**Our ref:** XA/2024/100222/01-L01

## **A46 Newark Bypass – Development Consent Order Application**

### **A46 from Farndon Roundabout to Winthorpe Roundabout, near Newark-On-Trent**

#### **Deadline 4 (13 December 2024)**

Figure 10: Slough Dyke realignment – extract from AS-007 (General Arrangement Plans) Sheet 25005

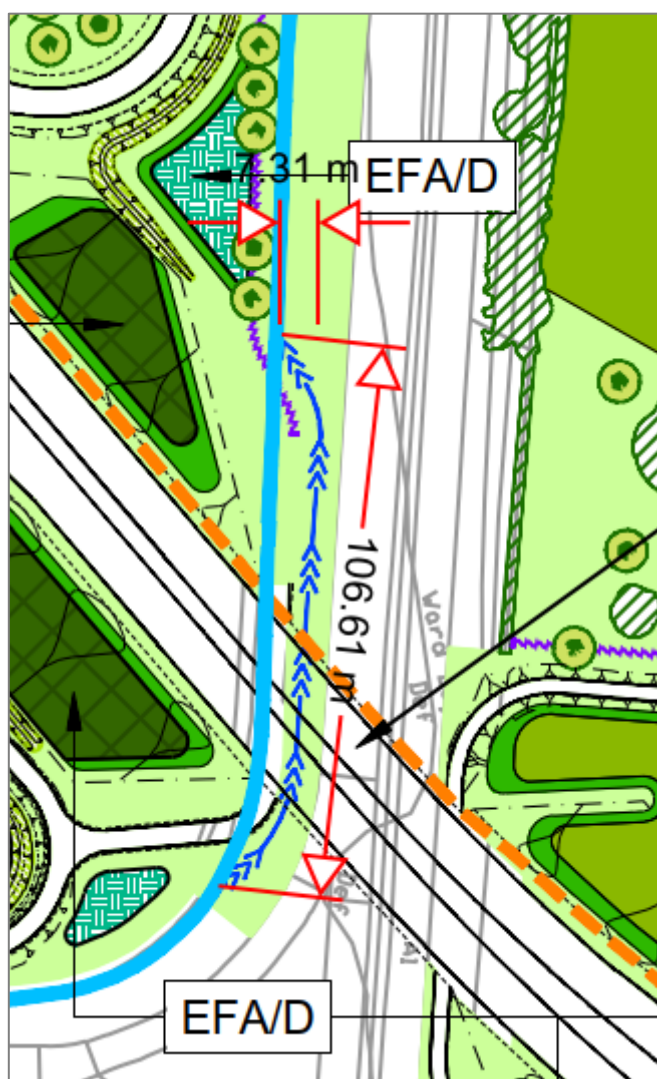
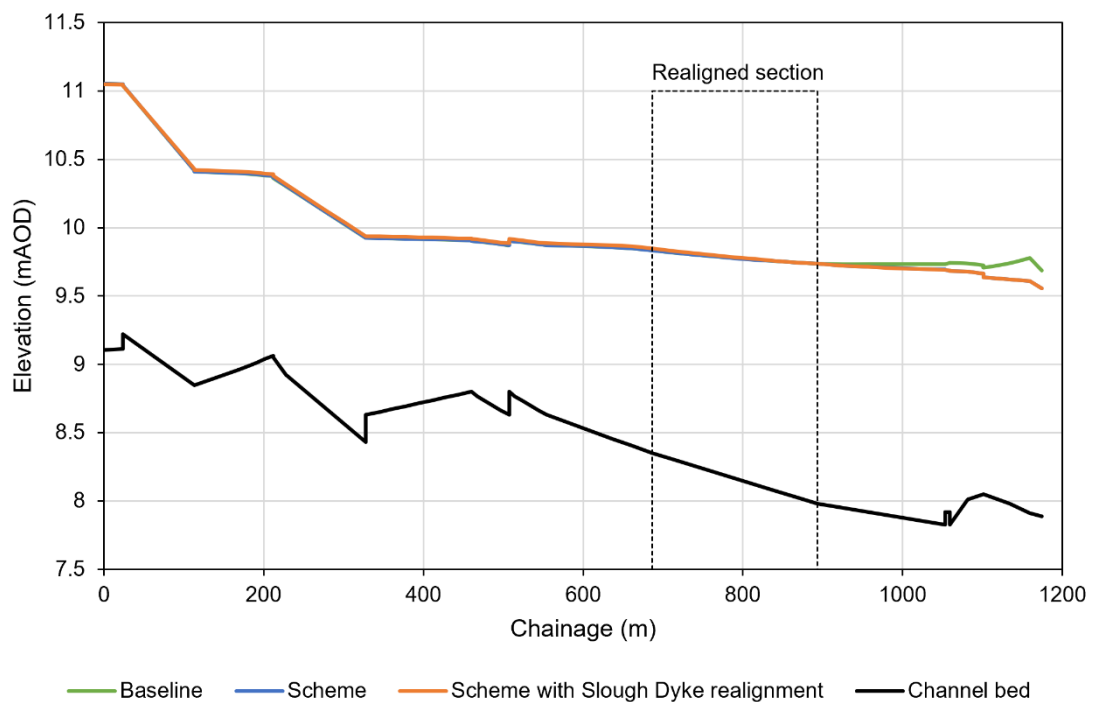
We added to the Applicant's response that from a hydraulic modelling point of view, we are satisfied with regards to the flood risk sensitivity test for the Slough Dyke realignment, in that it will not have any adverse effects on flood risk. However, we are still requesting some more detailed designs. This is regarding what the cross section of the channel will look like from that realignment, and also how it will tie into the existing channel and where these specific points will be located.

The Hydraulic Modelling Technical Note as referred to in our WR has now been submitted into the Examination at Deadline 3 [document ref. REP3-034]. This satisfactorily demonstrates that the realignment of Slough Dyke has been tested within the hydraulic model and confirms no impact on flood risk. However, we are still awaiting further detailed plans to clarify the proposed realignment.

Figure 16: 1% AEP. Fosse Road. Flood depth differences. Mitigated Scheme versus baseline. Original model.

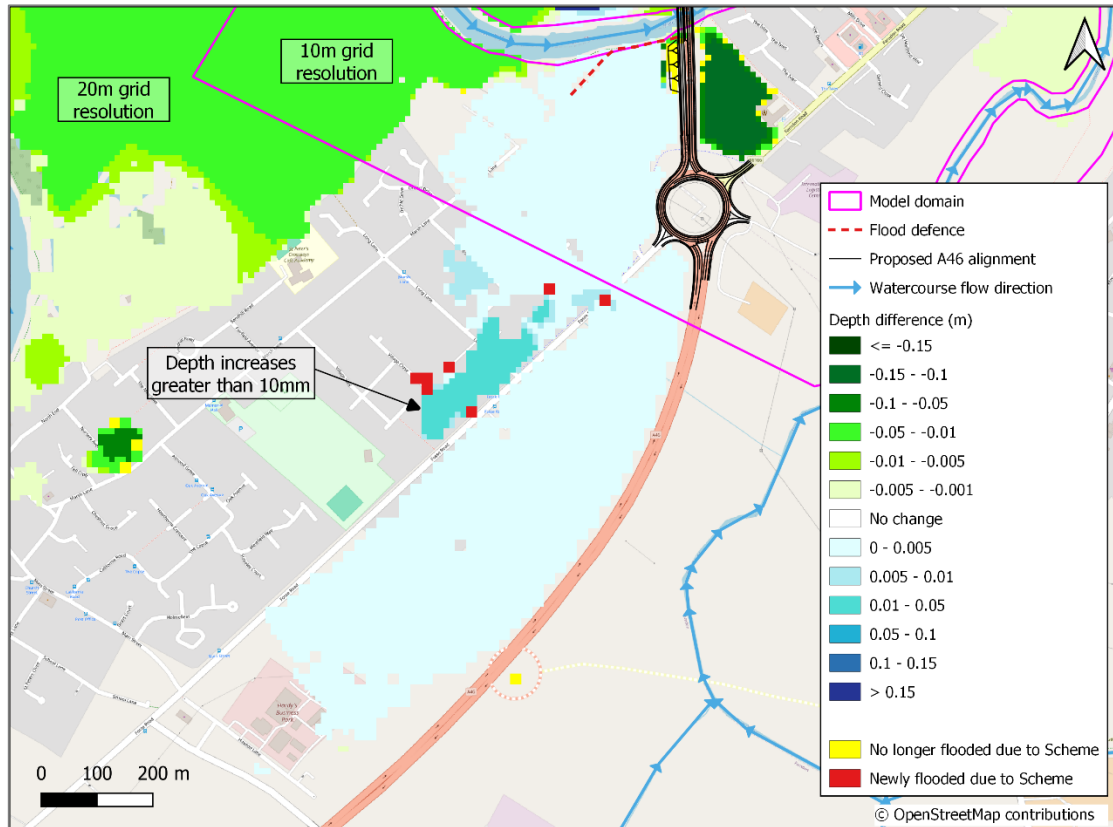
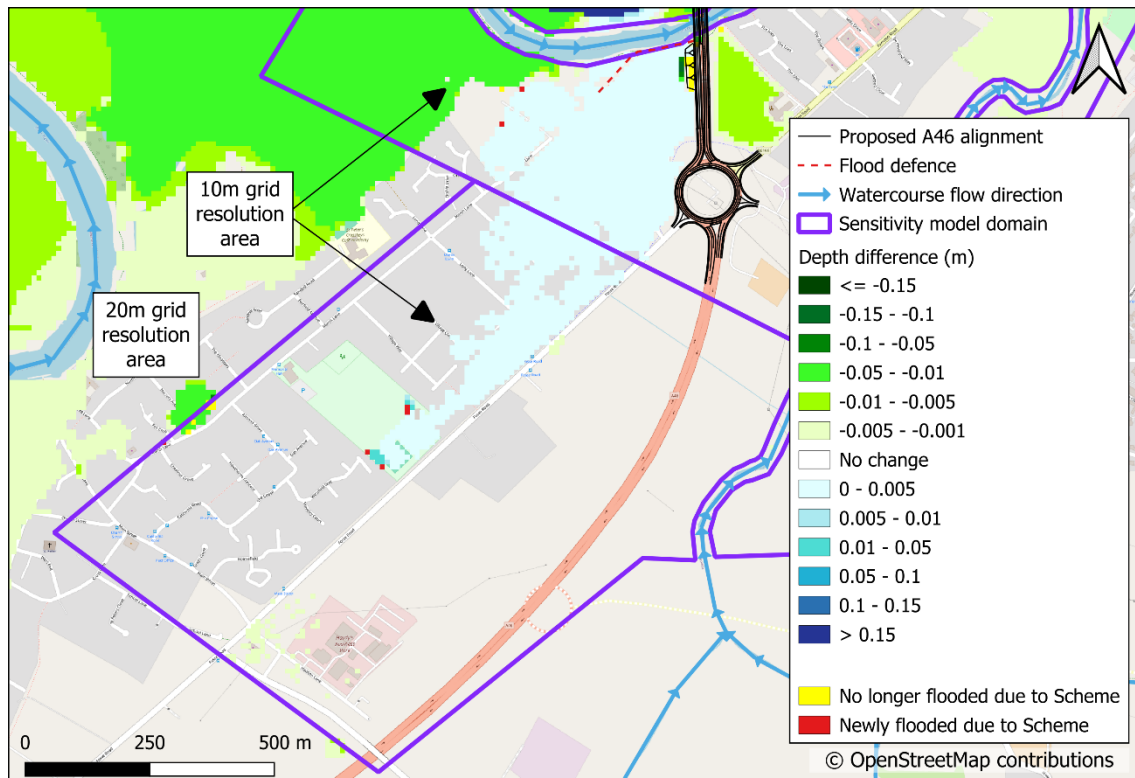
- There is an area of increase around Fosse Road in the 1 in 100 year flood scenario. The Hydraulic Modelling Technical Note [REP3-034] describes how the increases in water level around Fosse Road are due to modelling uncertainties and boundary effects which are occurring within the hydraulic model. We have sought further clarity from the Applicant with regards to the increases around Fosse Road and have suggested some approaches to them.
